**Re: Sawmill Building A at 1904 Bellamah Ave NW  
Erosion and Sediment Control Plan  
Engineer's Stamp Date 2/3/25 (J13E044A) SWQ-2025-00016**

Based on the information in your submittal received on 3/12/25, the ESC Plan can't be approved until the following comments are addressed. **The comments in red below refer to the resubmittal received on 3/26/25.**

C0

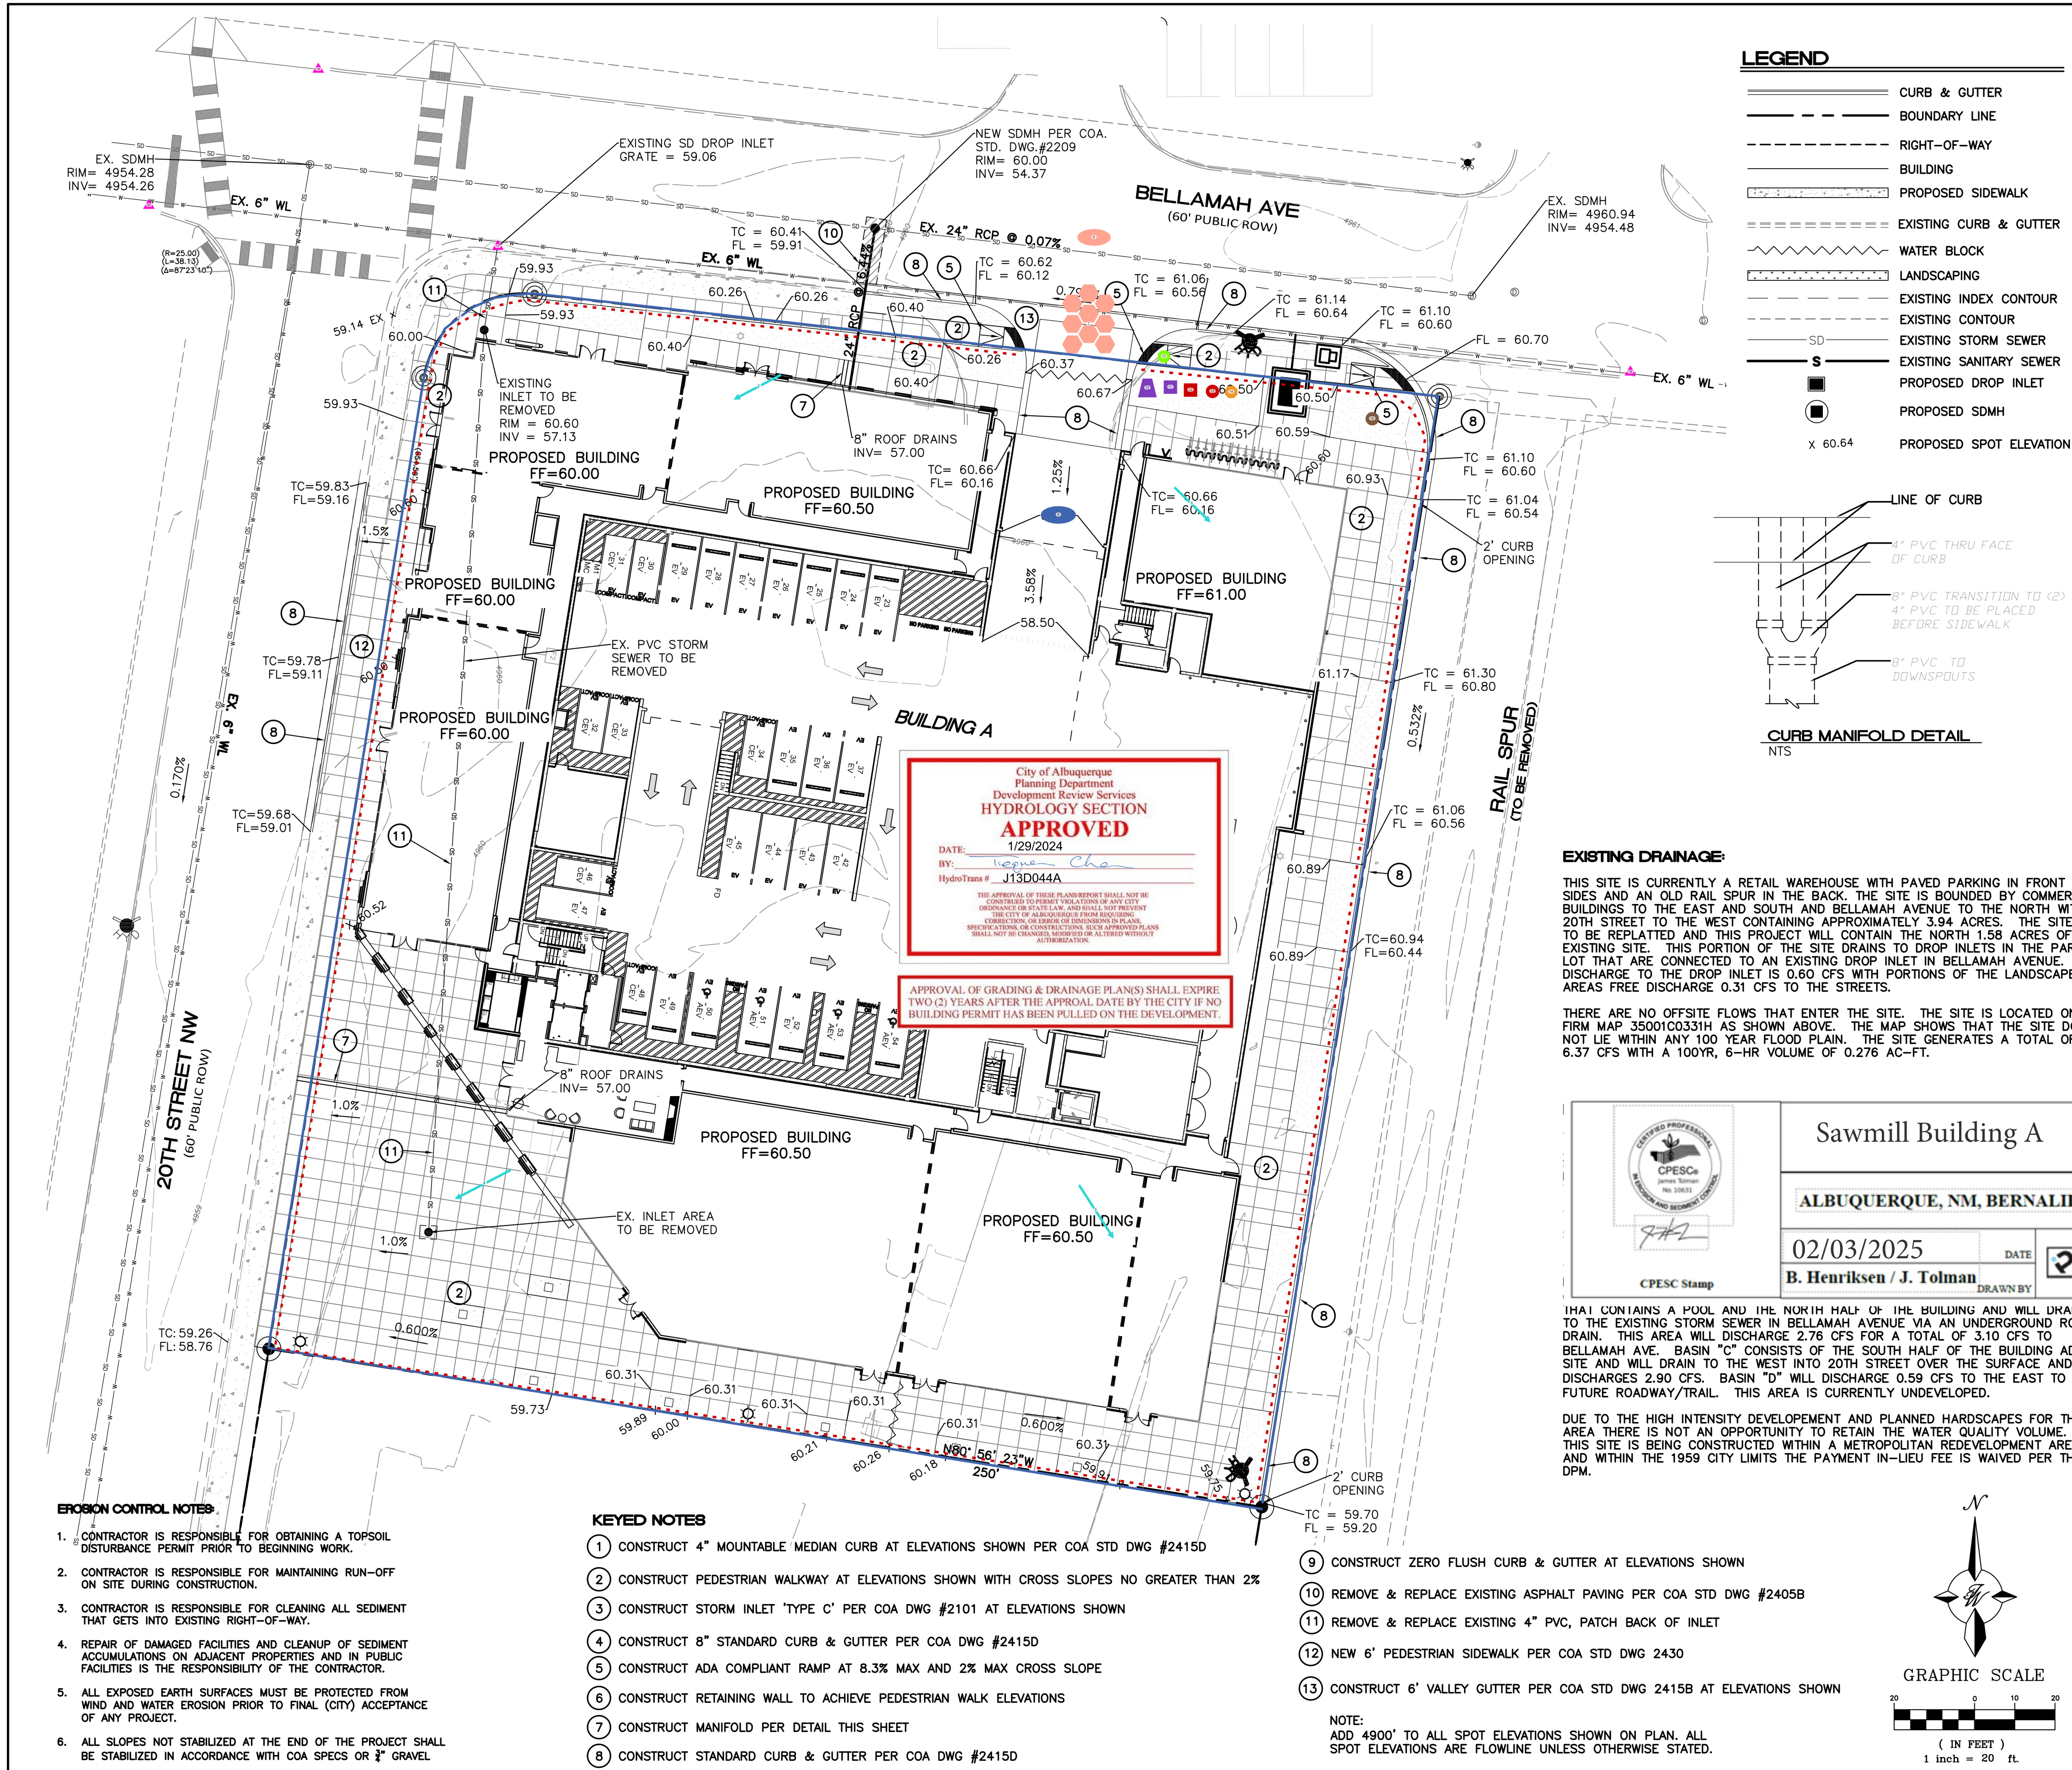
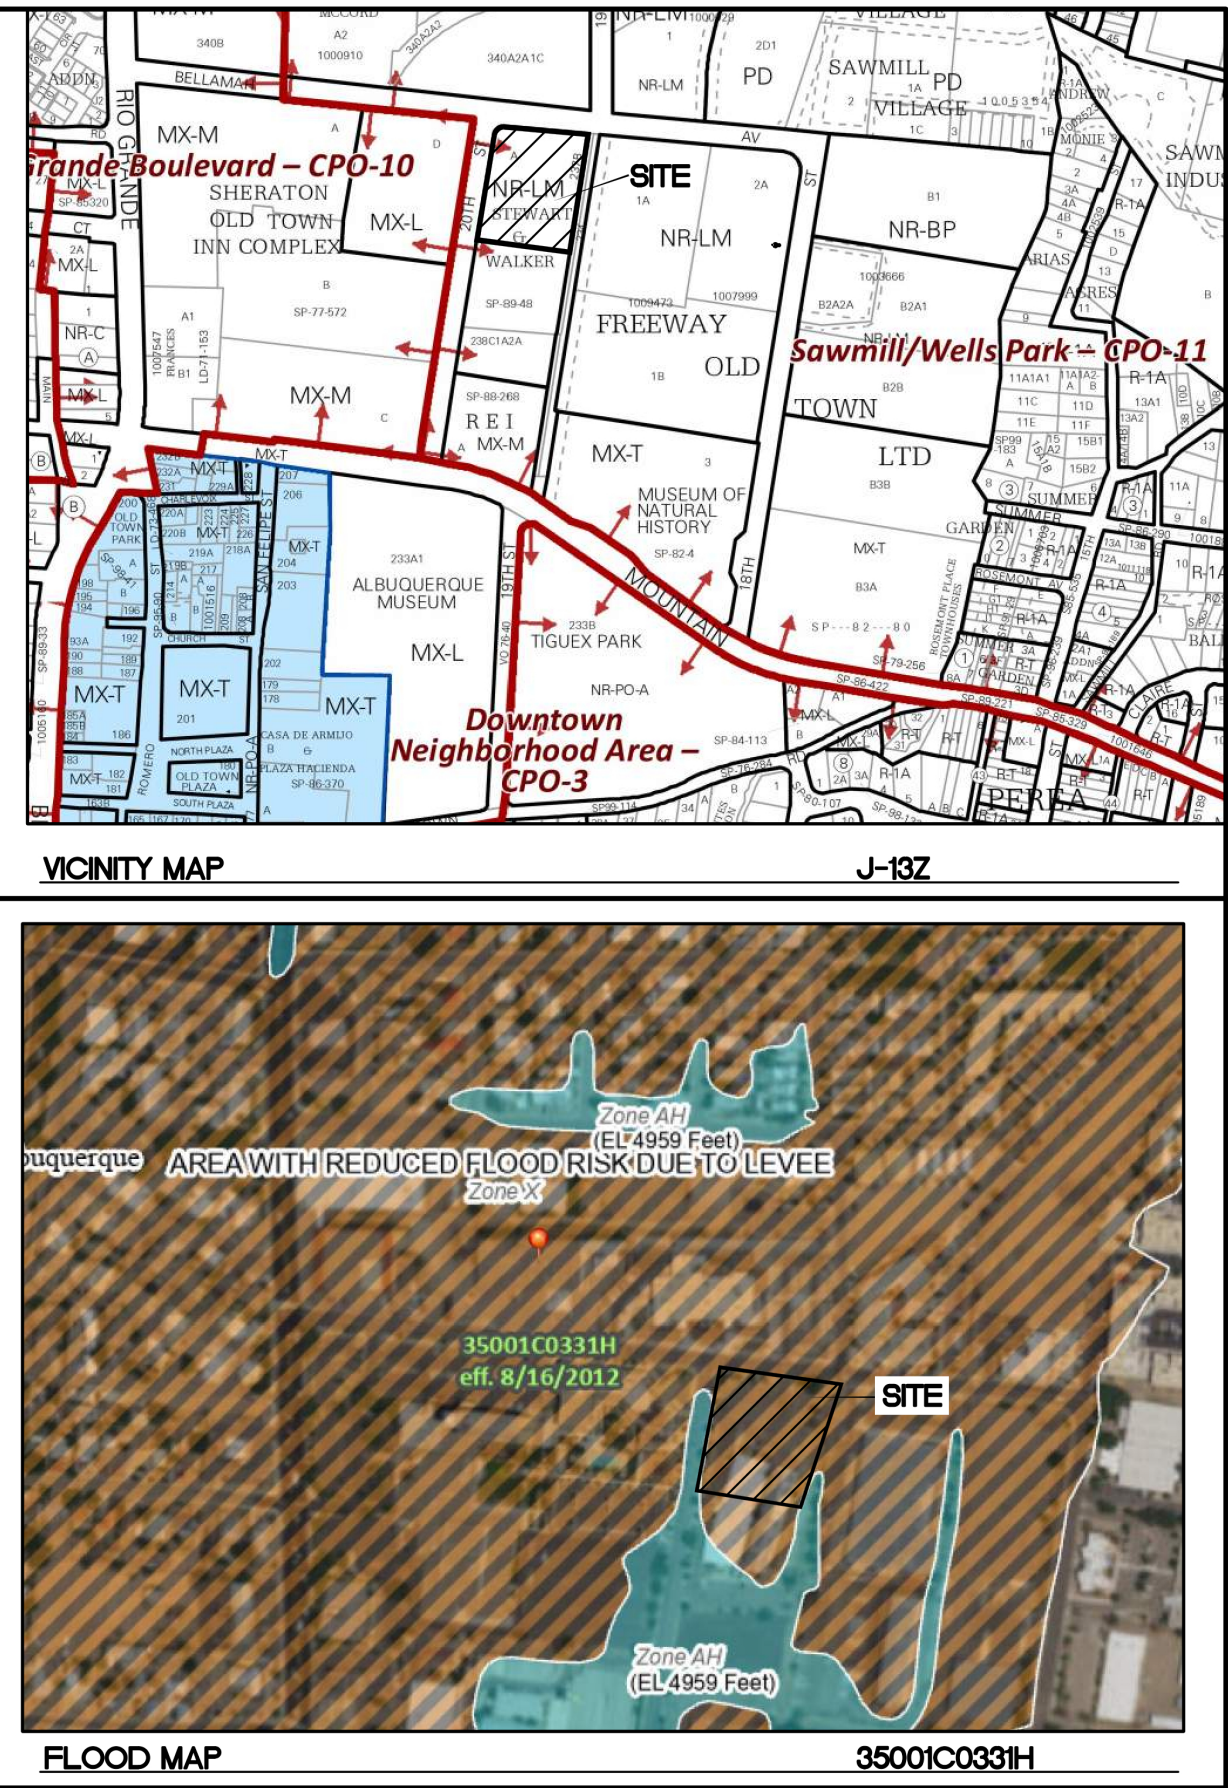
3. The estimated area of disturbance is incorrectly shown as 1.75 acres on the NOI and 1.58 acres on sheet 2 of the ESC Plan, but the demolition plan calls for the demolition of the entire 3.9-acre site. **OK, the area has been corrected.**
